Application for Planning Permission for Works or Extension to a Dwelling

Development: Single storey rear extension.
Location: 29 Victoria Road Bognor Regis PO21 2JE

Proposed Site Plan @ 1:500

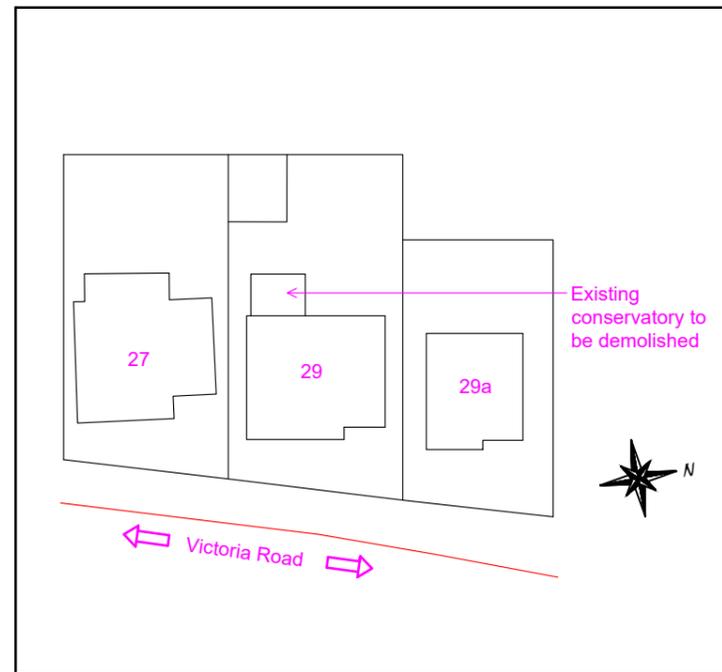
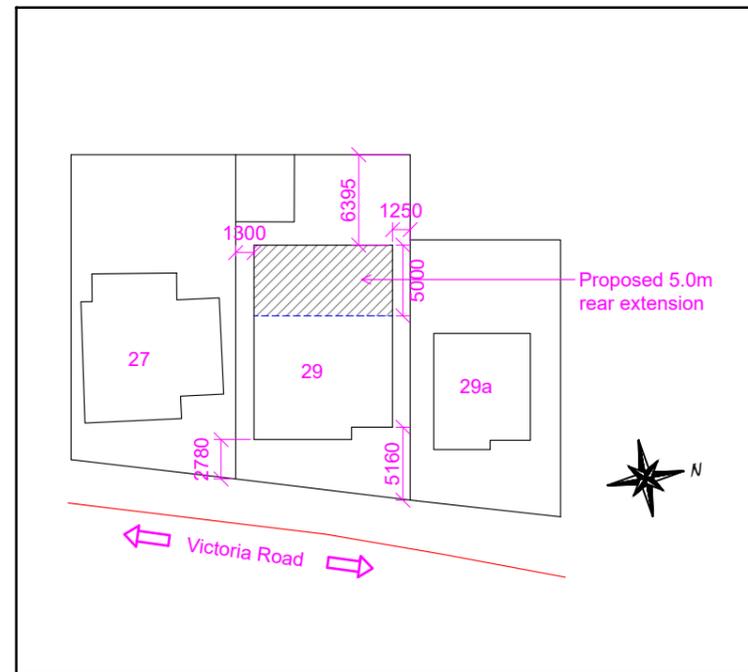
Block Plan

You are required to have dimensions from the proposed extension(s) to all site boundaries. Please amend.
